RE: Response to Request for Information for SSD 8858 & SSD 5175 MOD 5

Ethos Urban has prepared this letter on behalf of Frasers Property Australia in response to your letter dated 28 November 2019 and the associated submissions received during the exhibition period of SSD 8858 and SSD 5175 MOD 5, relating to Stage 2 of the Eastern Creek Business Hub development.

PROPOSED GROUND FLOOR PLAN - SIGNAGE 1 : 500

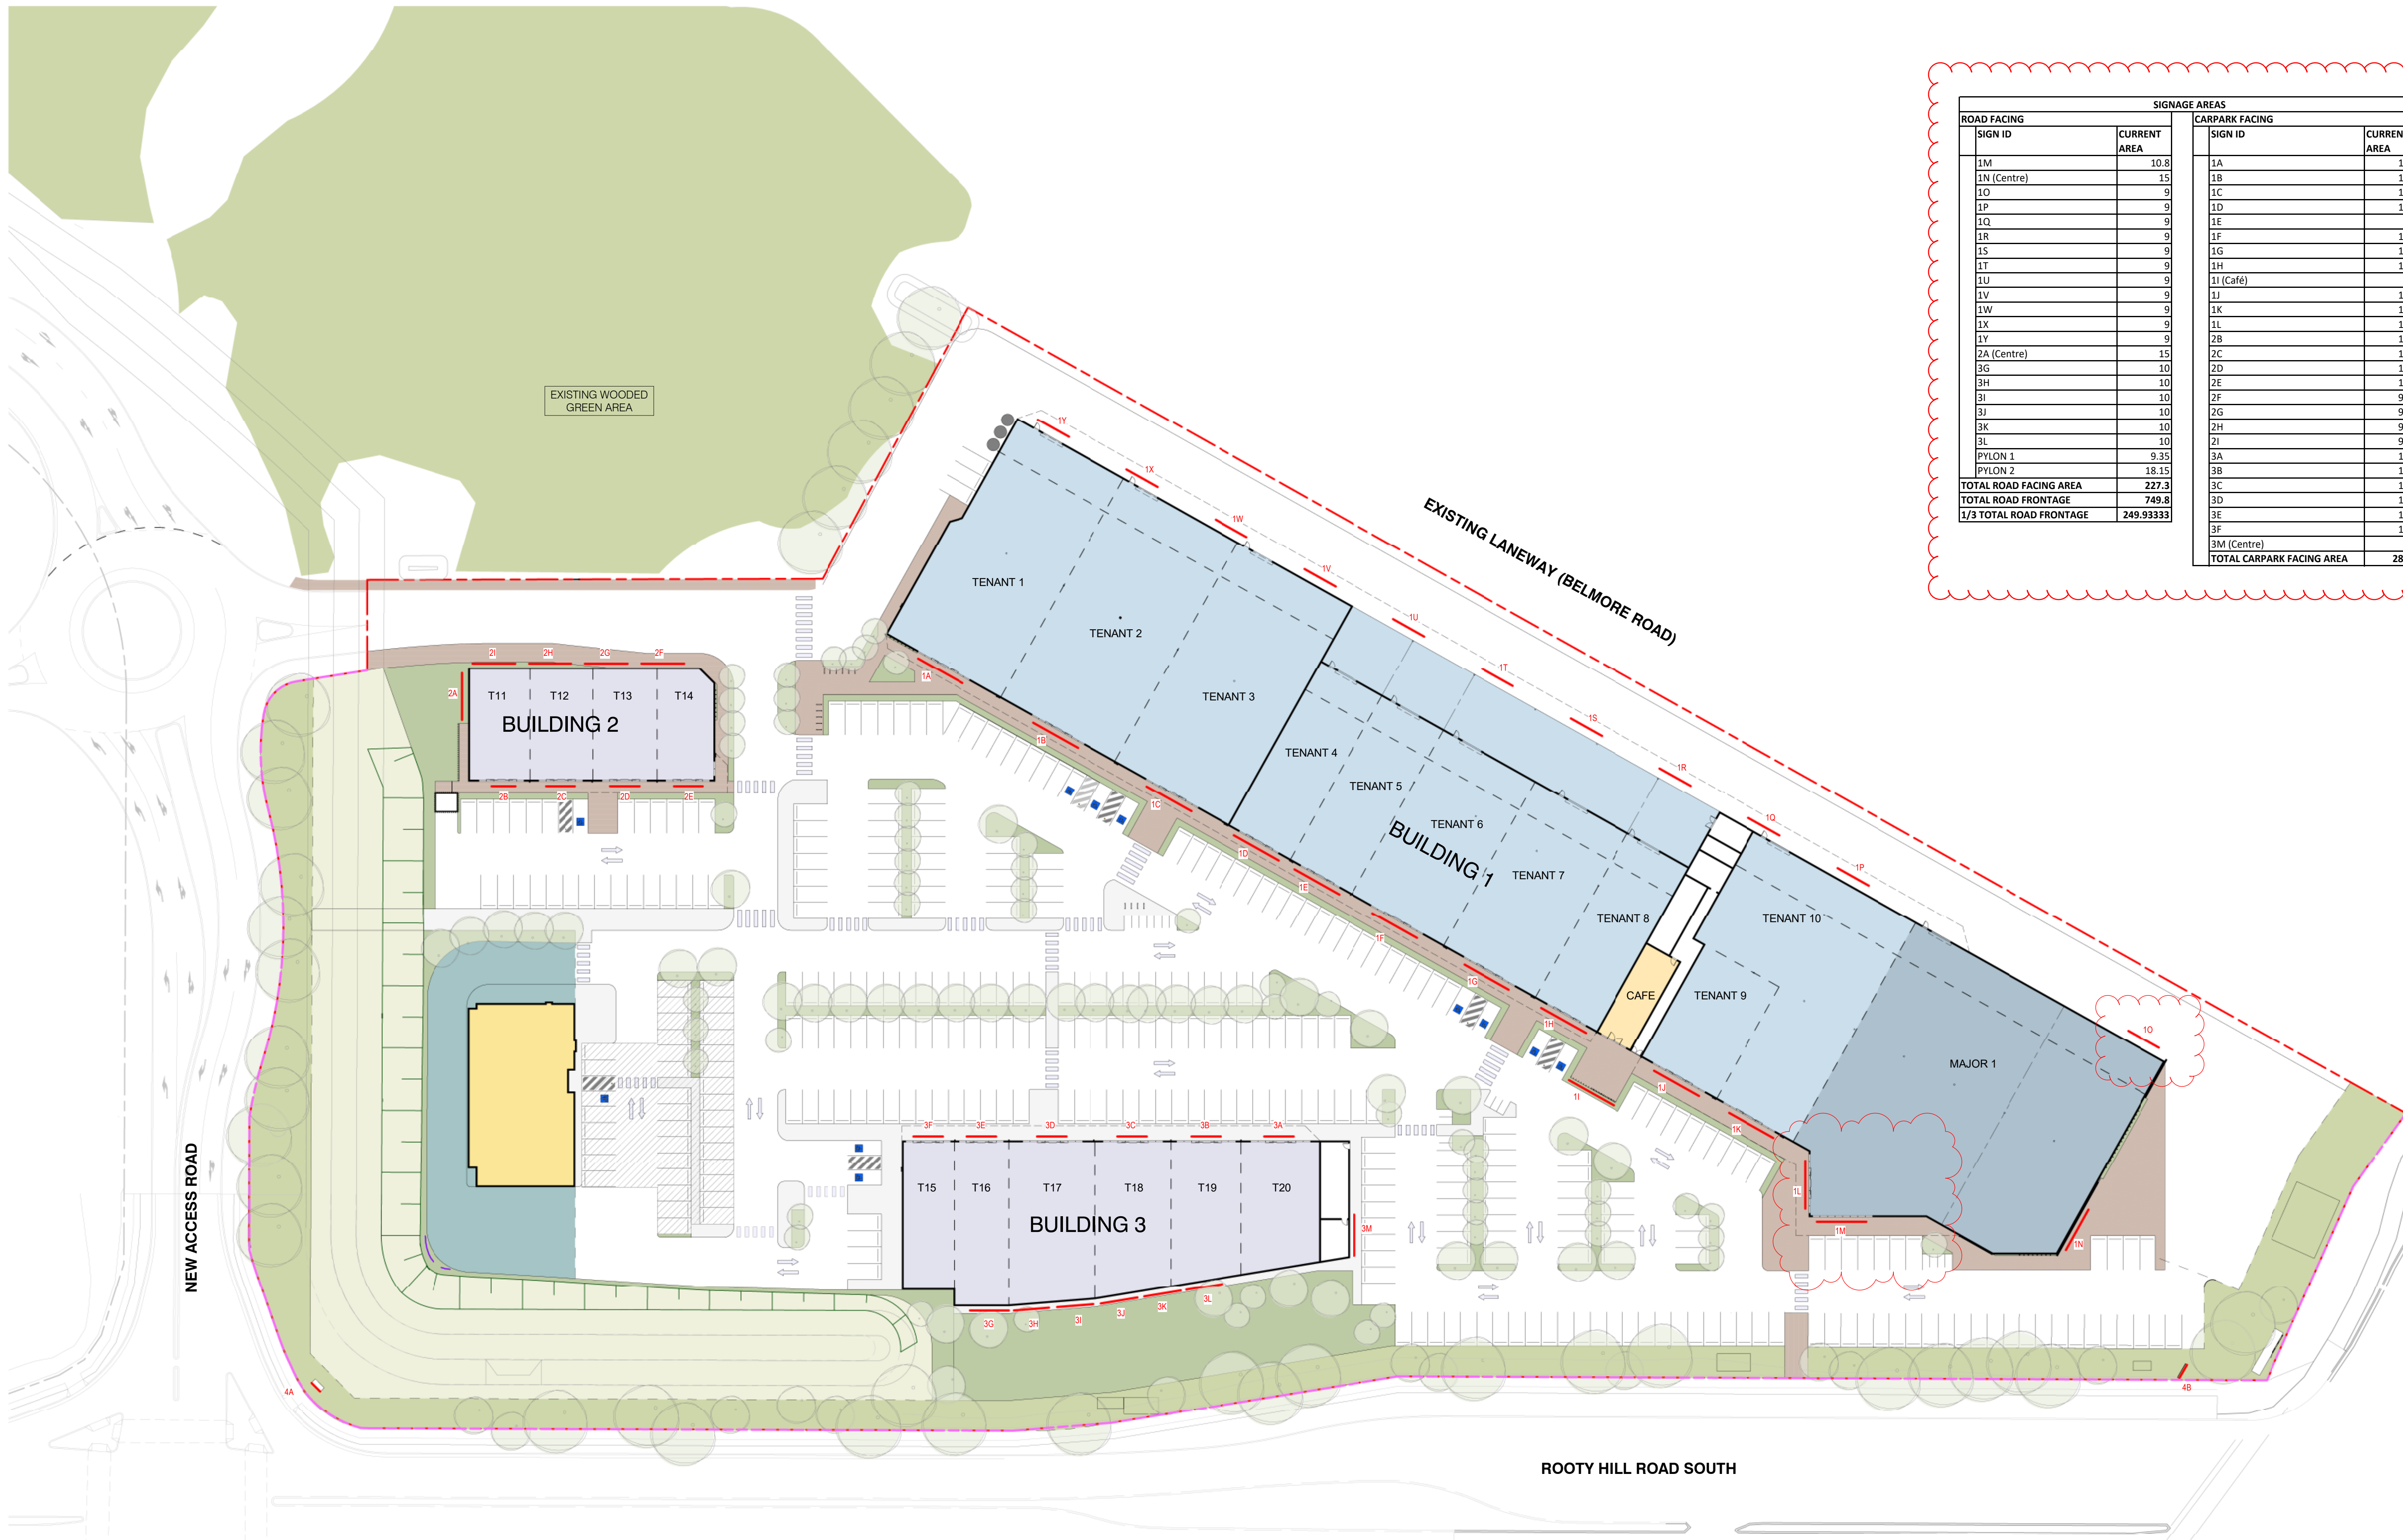
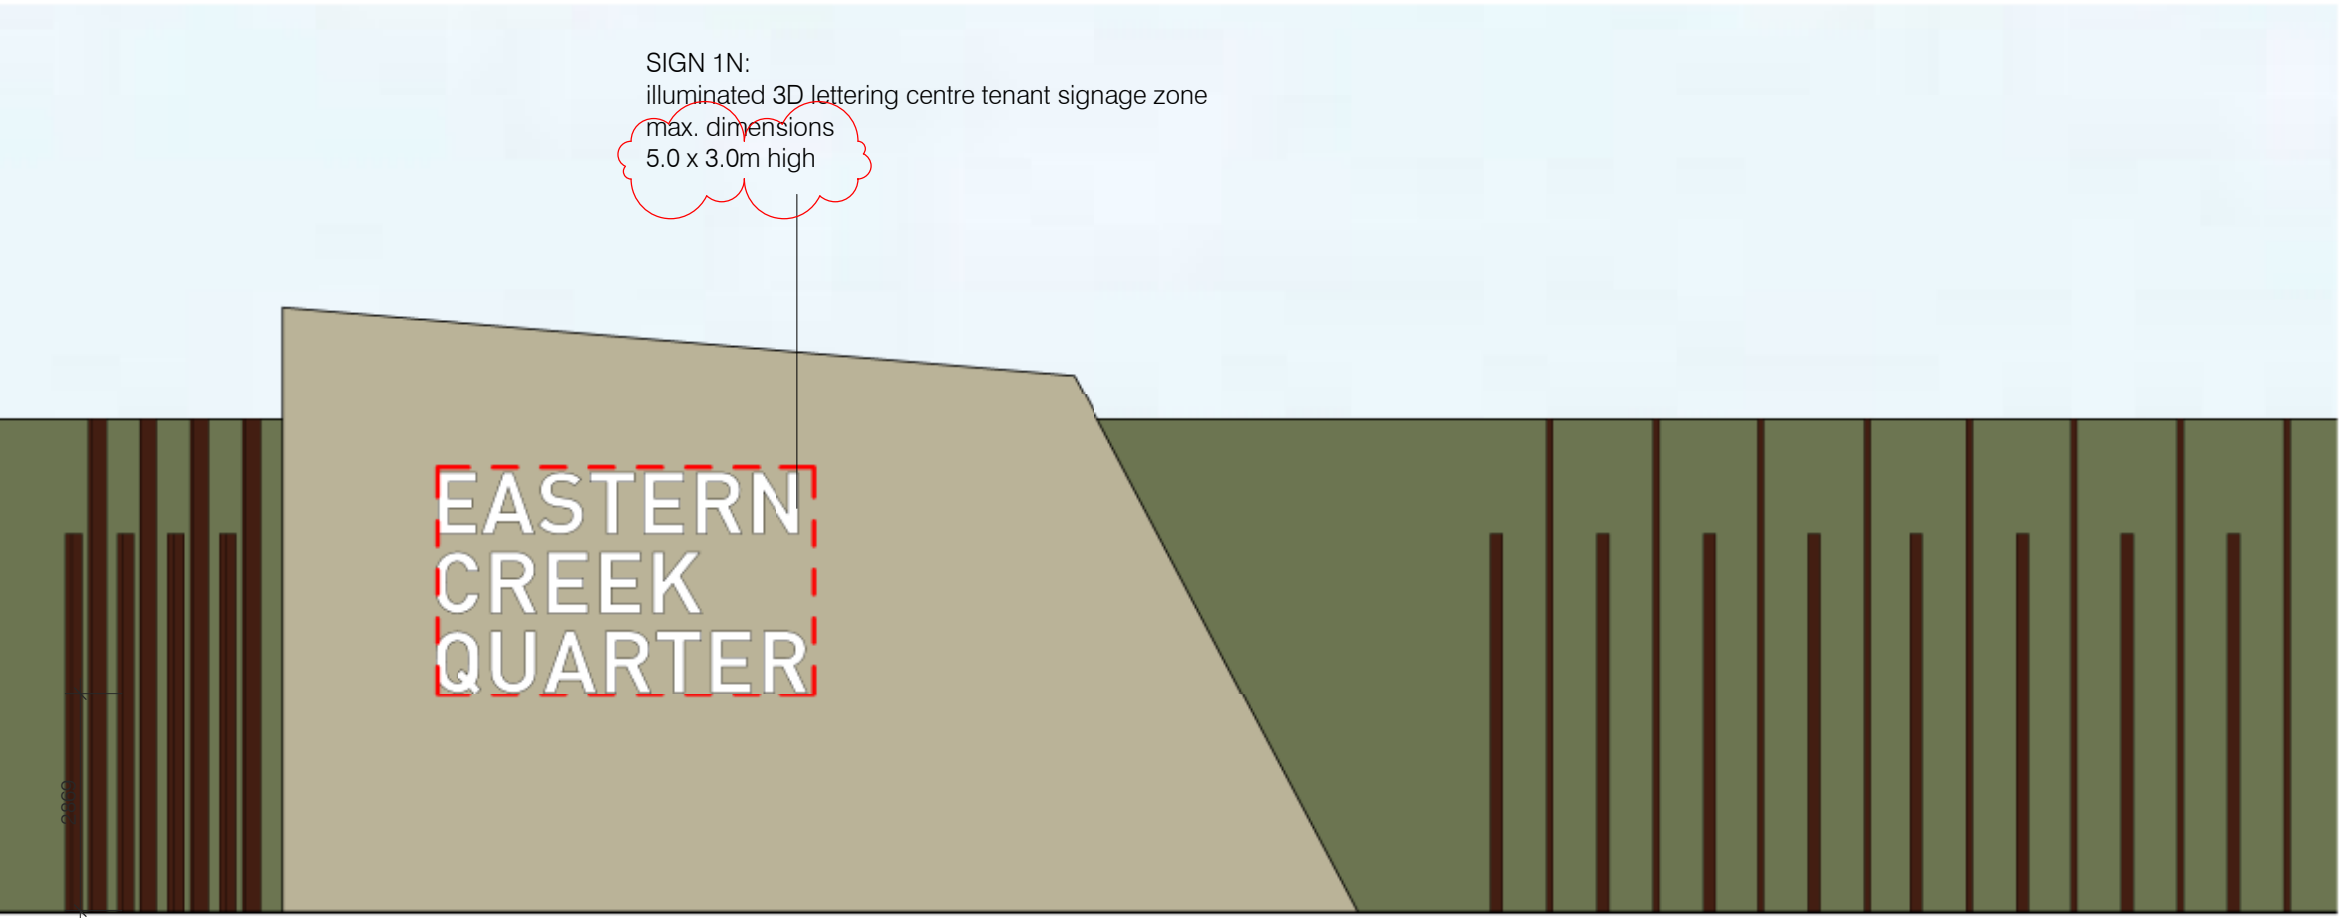
Signage Provide additional justification for the signage zones on the front and rear of the three specialised retail buildings having regard to the private domain signage controls within the Design Guidelines, including: - advertising signage for the business hub should be kept to a minimum - for single developments the total permissible signage and advertisements are not to exceed 1 sqm of advertising per 3m of street frontage.	The proposal seeks to strike a balance between minimising the overall quantum of advertising signage whilst providing for the requirements of the specialised retail tenancies and general wayfinding. It is noted that the change in layout of the centre from one large specialised retail centre building to three smaller buildings, results in additional building frontages (most of which are internal to the site). The proposal allows for each tenant to have one individual front and rear sign which is considered appropriate for a development of this nature and use, and is in line with other comparable large format retail centres. The proposed signage is integrated into the architectural form of the building and their scale, form and proportion is appropriate for the setting and will contribute to the visual interest and viability of the site. The signage will not obscure or compromise any important views. Notwithstanding, the proposed signage strategy has been amended (Attachment E) to reduce the size of signs across the site in response to this issue. The proposal reduces the amount of road facing signage from 350sqm to 227sqm which complies with this control based on a total road frontage of 750m. It is noted that this calculation is based on road facing signs and not inward facing signs which is considered consistent with the intent of the control in context of the modified built form.
